From: Bradley Gasawski
Sent: Monday, December 22, 2025 11:16 AM
To: Candy Rinehart
Cc: Jamey Ayling; Bradley Gasawski; Zach Torrance-Smith; Ellie Myers
Subject: RE: Rinehart Boundary Line Adjustment (BL-25-00023)
Attachments: BL-25-00023 Rinehart - Acreage Numbers.xlsx

- Please double check the existing acreage of parcel # 279433. County records show 60.41 acres, and your application shows 60.14 acres. If 60.14 acres is the correct acreage because a recent survey resulted in that acreage, we'll use it. Otherwise, the 60.14 acres could be a typo so I wanted to double check this acreage with you. Please confirm the acreage for parcel # 279433.

**EXISTING**

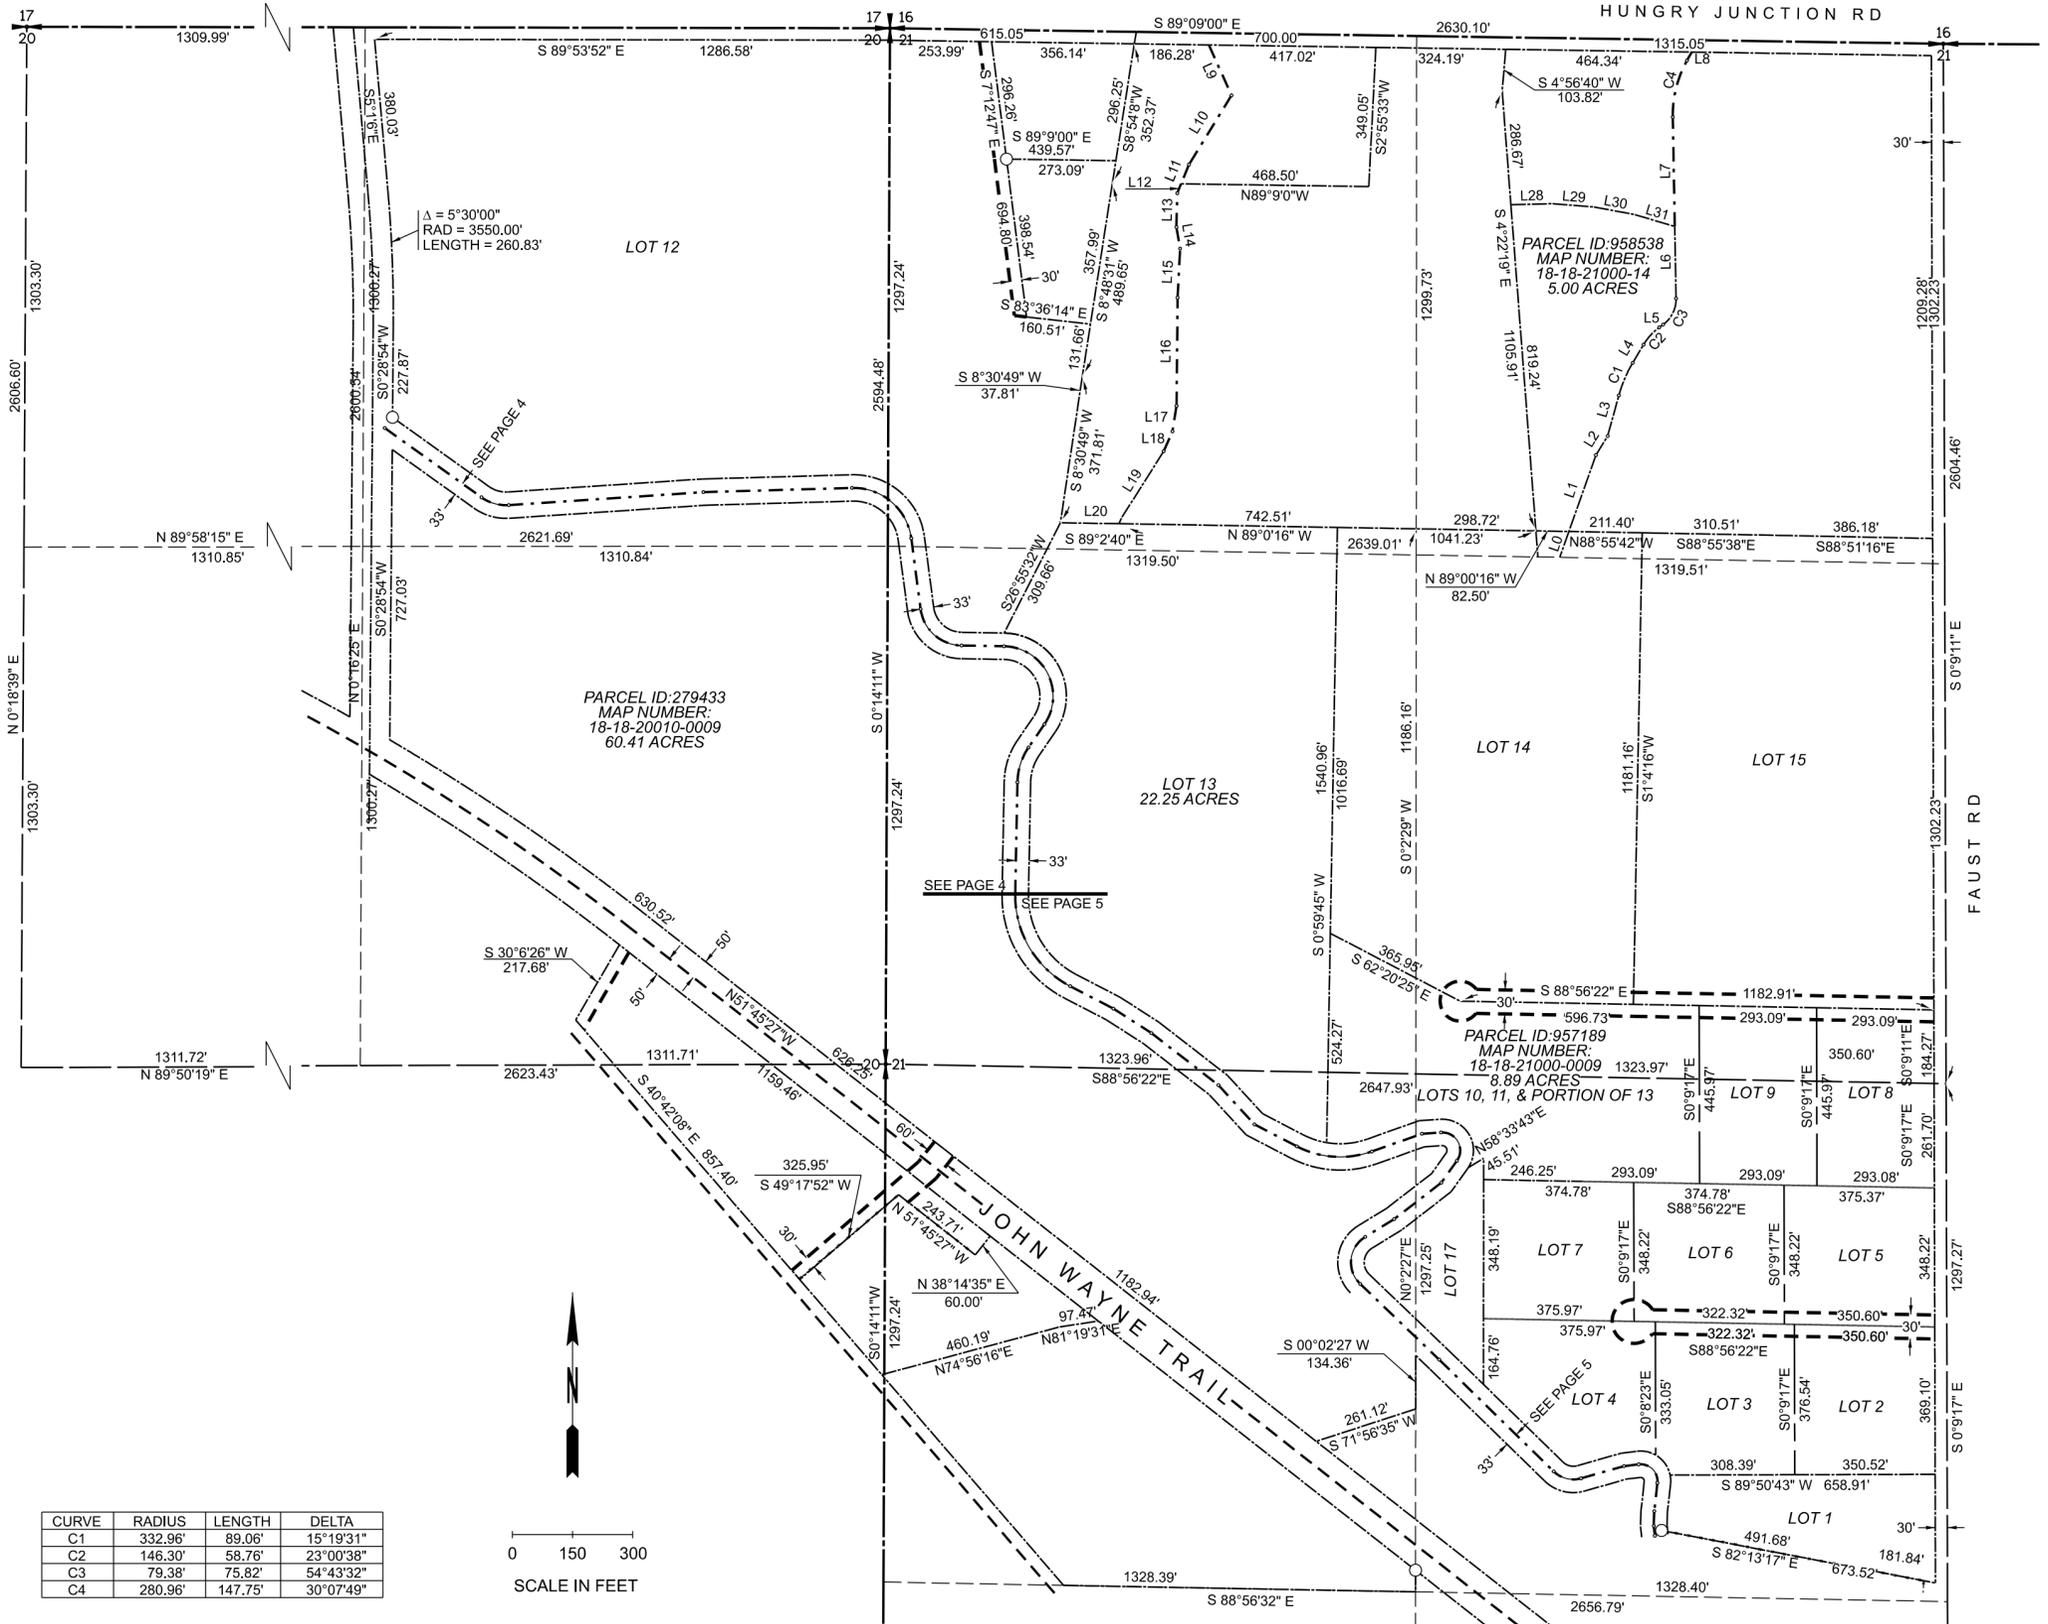
- When I run the total acreage calculations, the original and new acreage numbers do not match. I get a difference of around 8.5 acres of additional acreage as a result of the BLA. My calculations show existing acreage at 220.7 and proposed acreage of 229.25. I've attached an excel spreadsheet to this email so that you can see what I'm using. The difference between 60.41 & 60.14 acres would change the total existing acreage used, but the change is only 0.27 acres. Please double check the proposed acreage and resubmit. In the spreadsheet, the yellow highlighted row is parcel # 279433. The total existing and proposed acreage is highlighted in green.
